From: [Doug & Yi](#)
To: [Rachael Stevie \(CD\)](#)
Subject: Comments regarding variance request, application # "RU 22-00002"
Date: Wednesday, April 20, 2022 9:47:36 PM

Please consider the following comments before voting on this variance request.

MITIGATION SITE PLAN, NOTES, & DETAILS

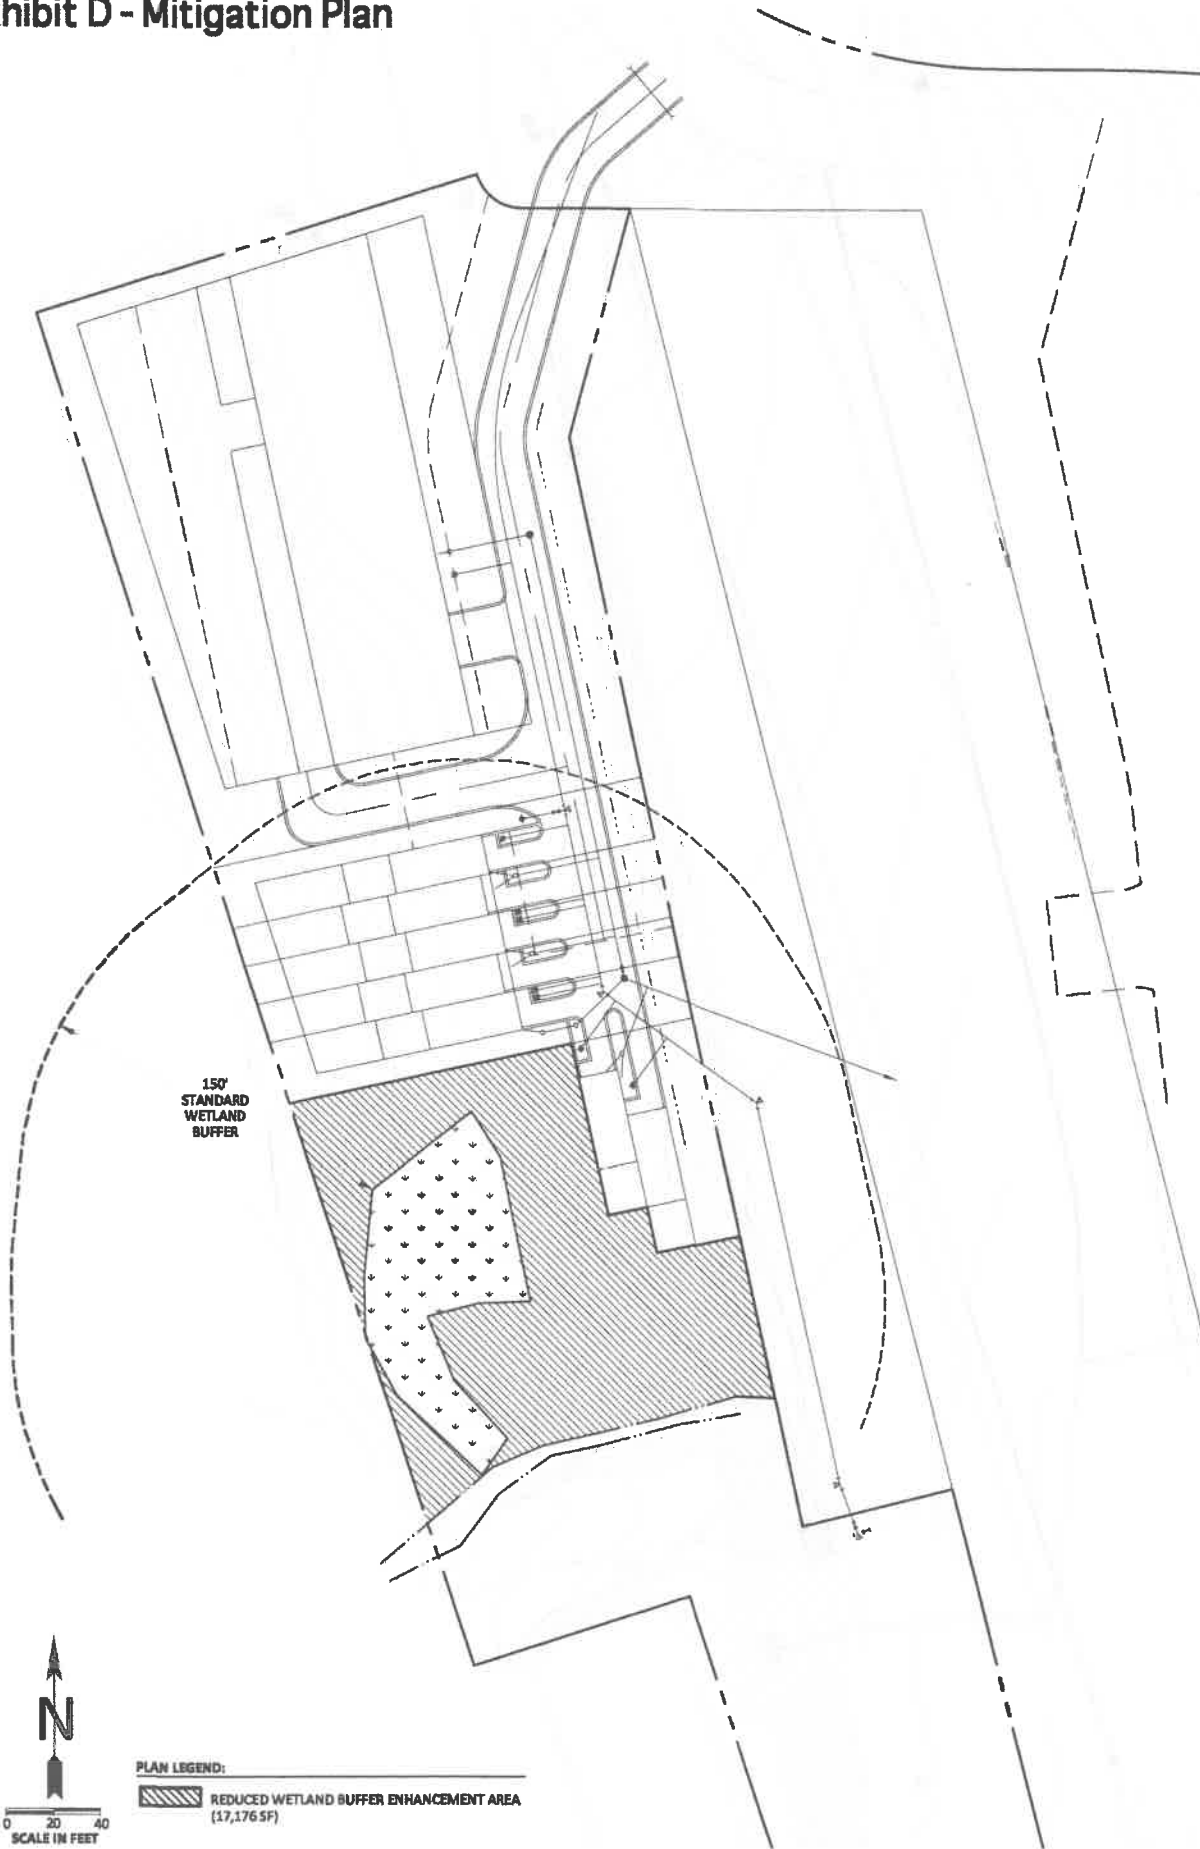
other downstream paths. This stream in turn is dependent of the surrounding undergrowth and trees that prevent erosion and degradation of the current drainage patterns. In the event that this variance is approved, the drainage of this watershed will be negatively impacted. The developer's mitigation plan is not, in my opinion, sufficient to protect the natural resources and drainage.
